DRB CASE ACTION LOG
REVISED 10/08/07

DRB Application No.: 09DRB-70103 Project # 1007681
Project Name: Pomeroy Addn
Agent: Community Sciences Corp. Phone No.: _____

DRB Comments

RE: Lots 1 & 2, Pomerenk Addition

SKETCH PLAT OF LOT 1-A OF POMERENK ADDITION

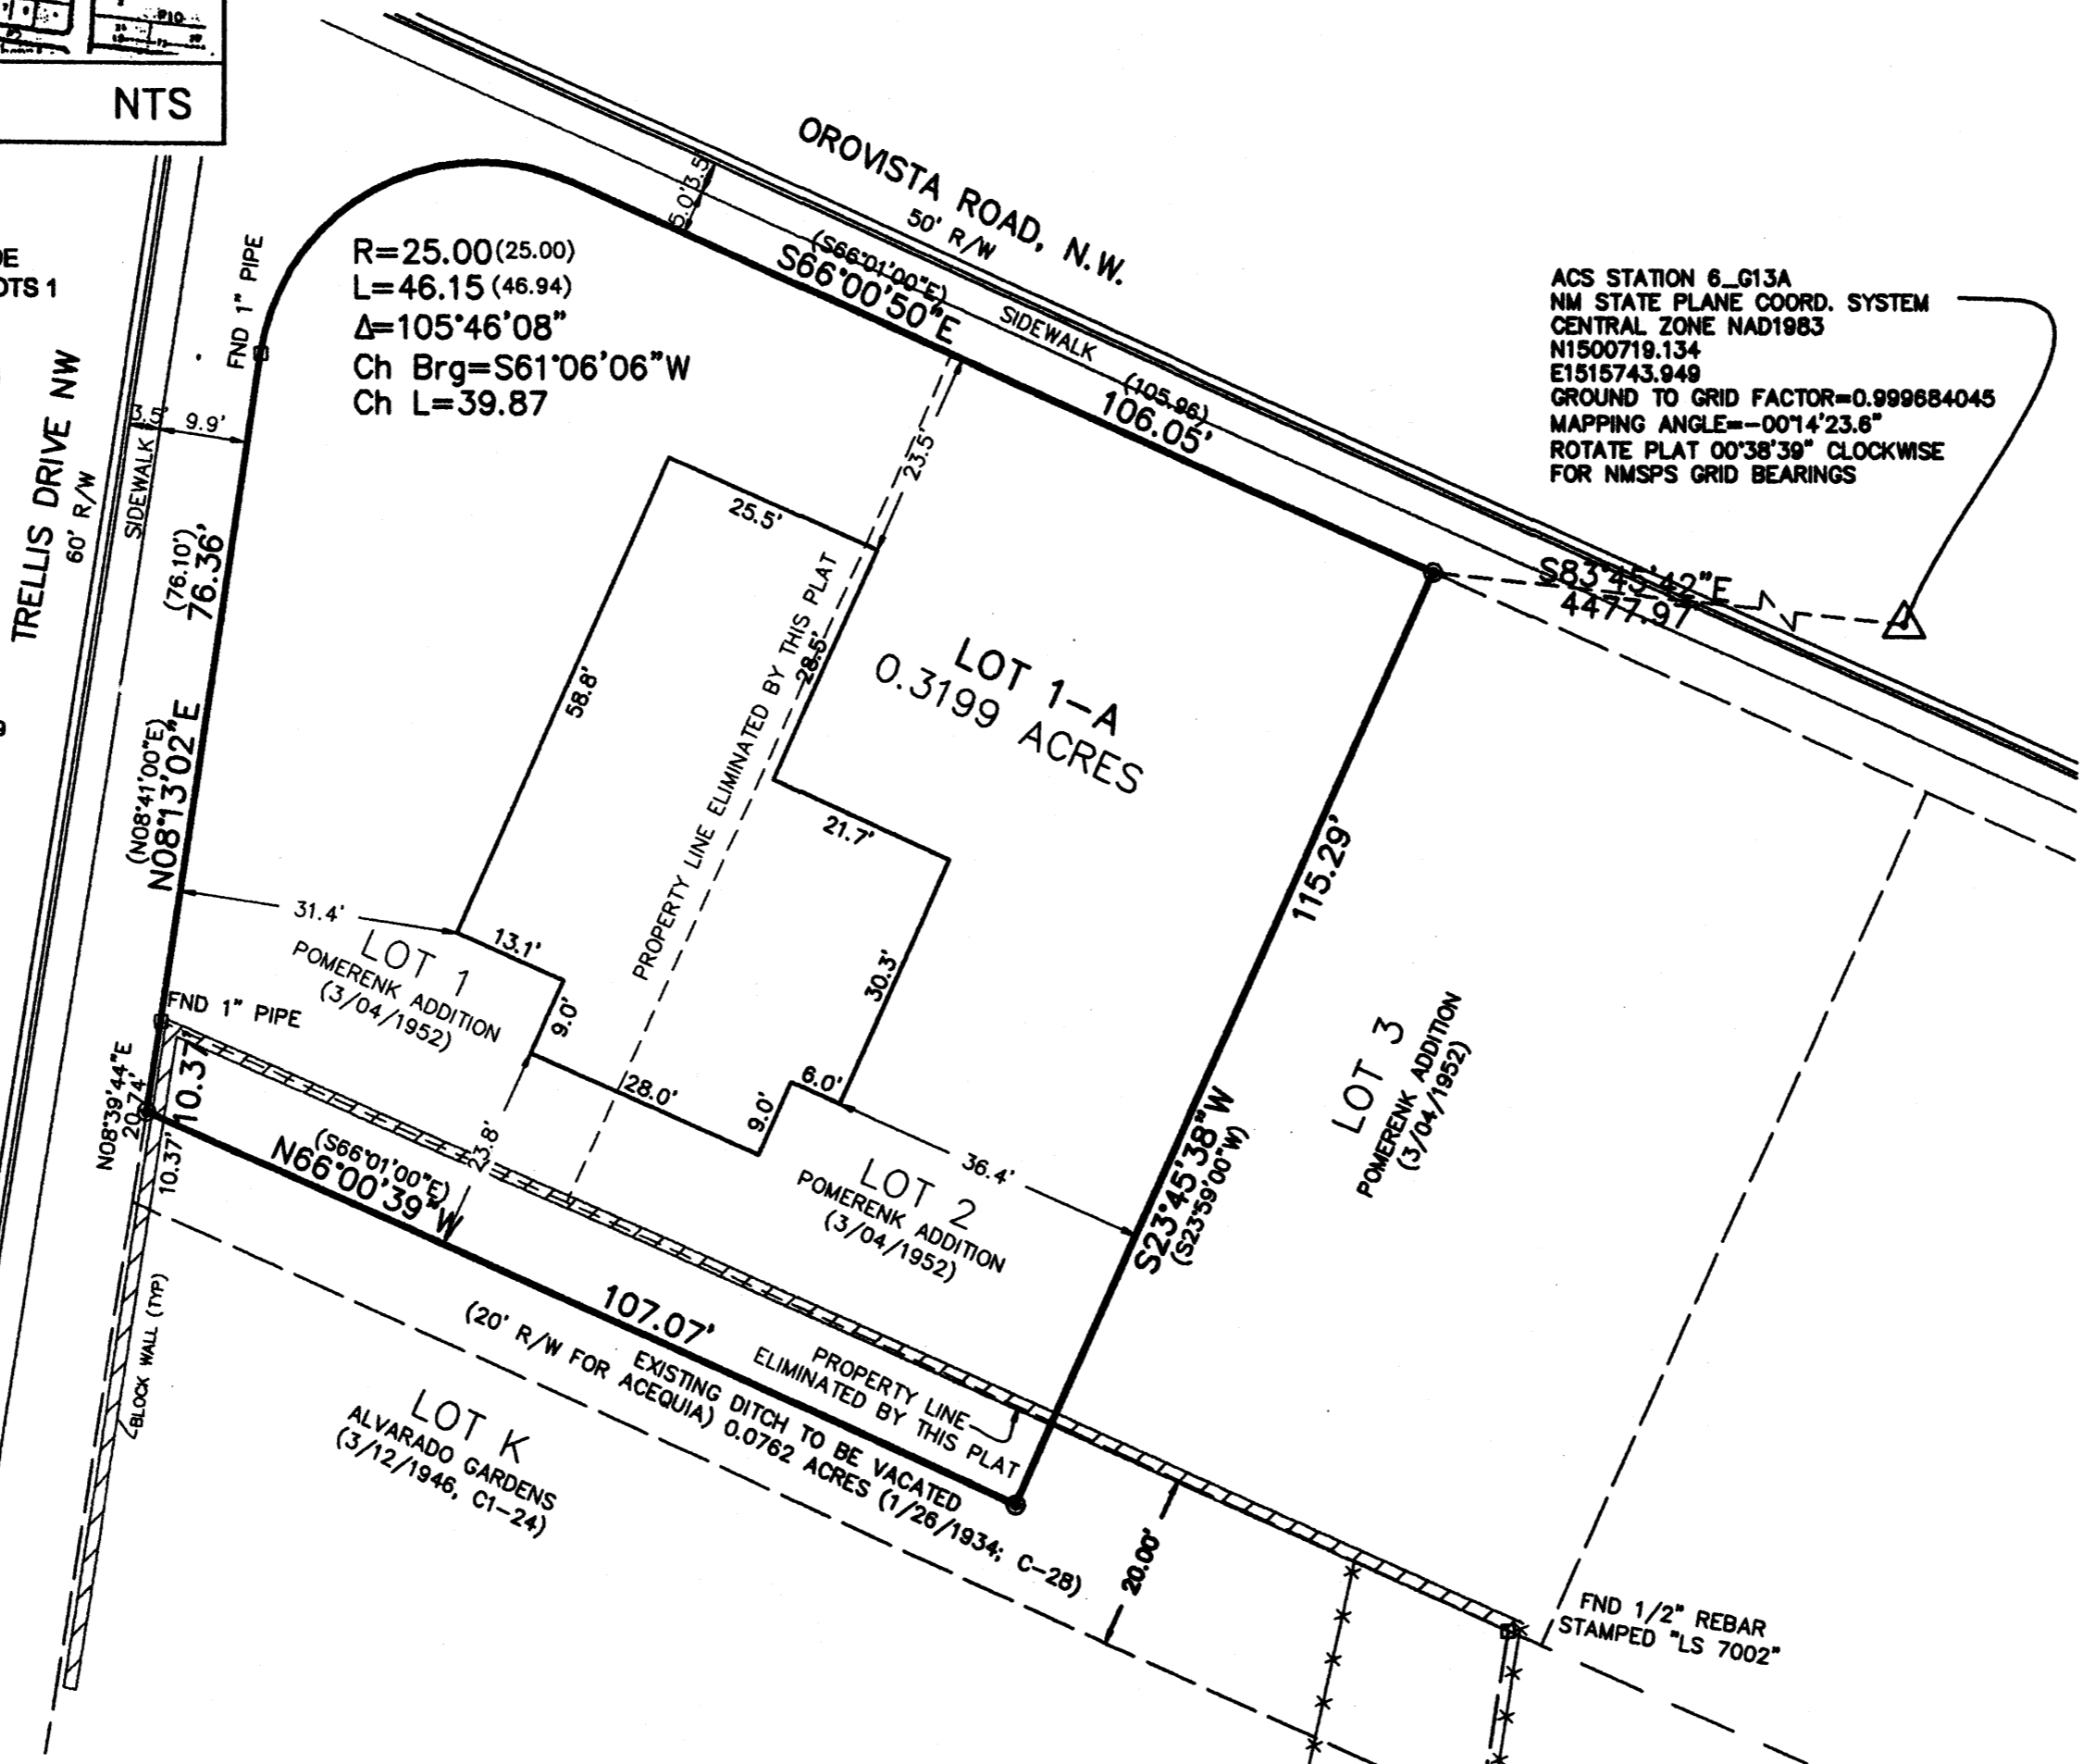
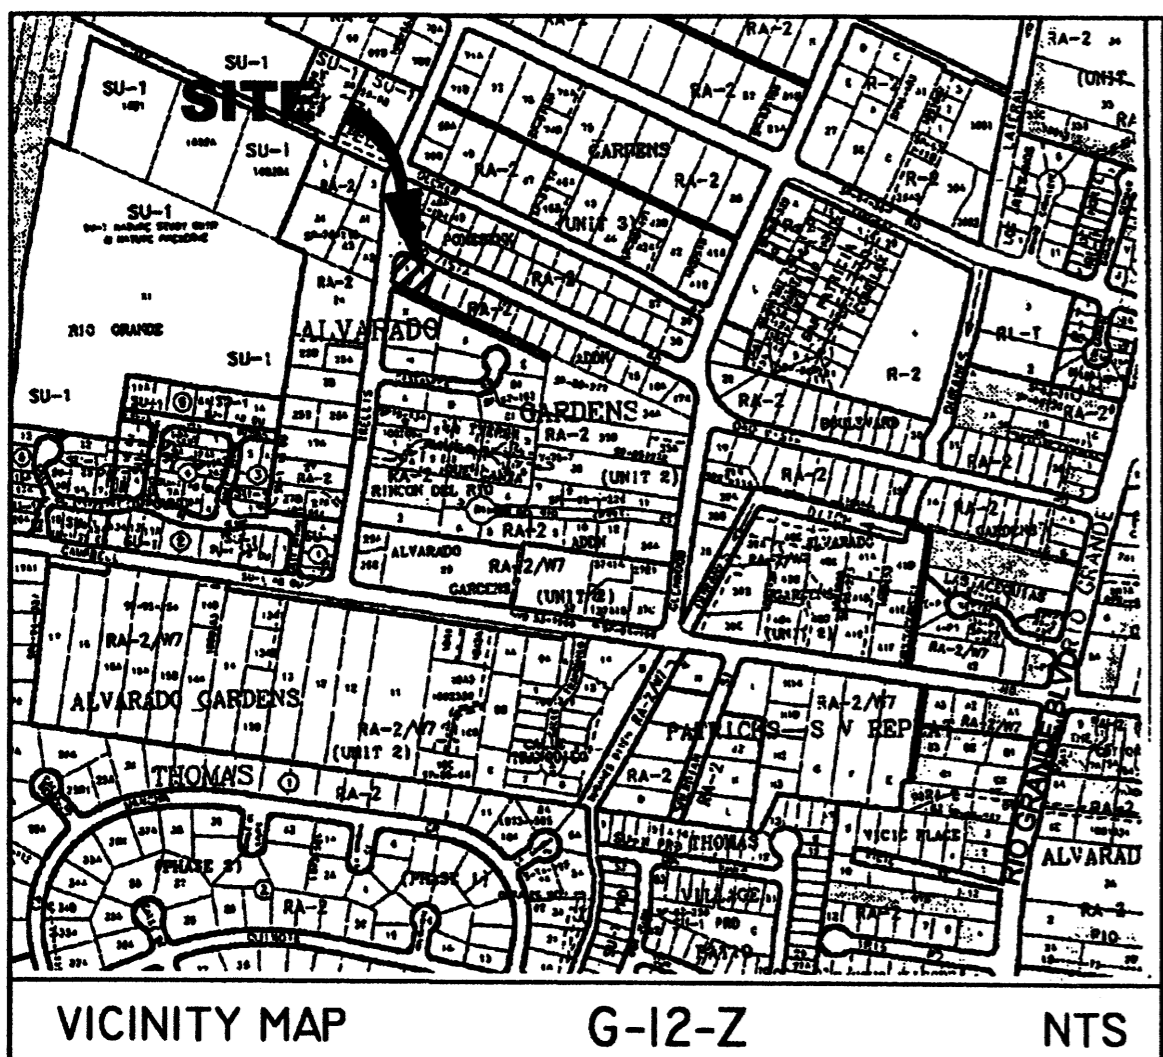
A Solar Note will be needed on the plat (consistent with Section 14-14-4-7 of the Subdivision Ordinance) which is specific to this type of request, i.e. use the words "THIS PLAT" (rather than the words "REQUESTED FINAL ACTION") at the beginning of the note, and do not use the words "OR SITE DEVELOPMENT PLAN FOR SUBDIVISION" at the end of the note.
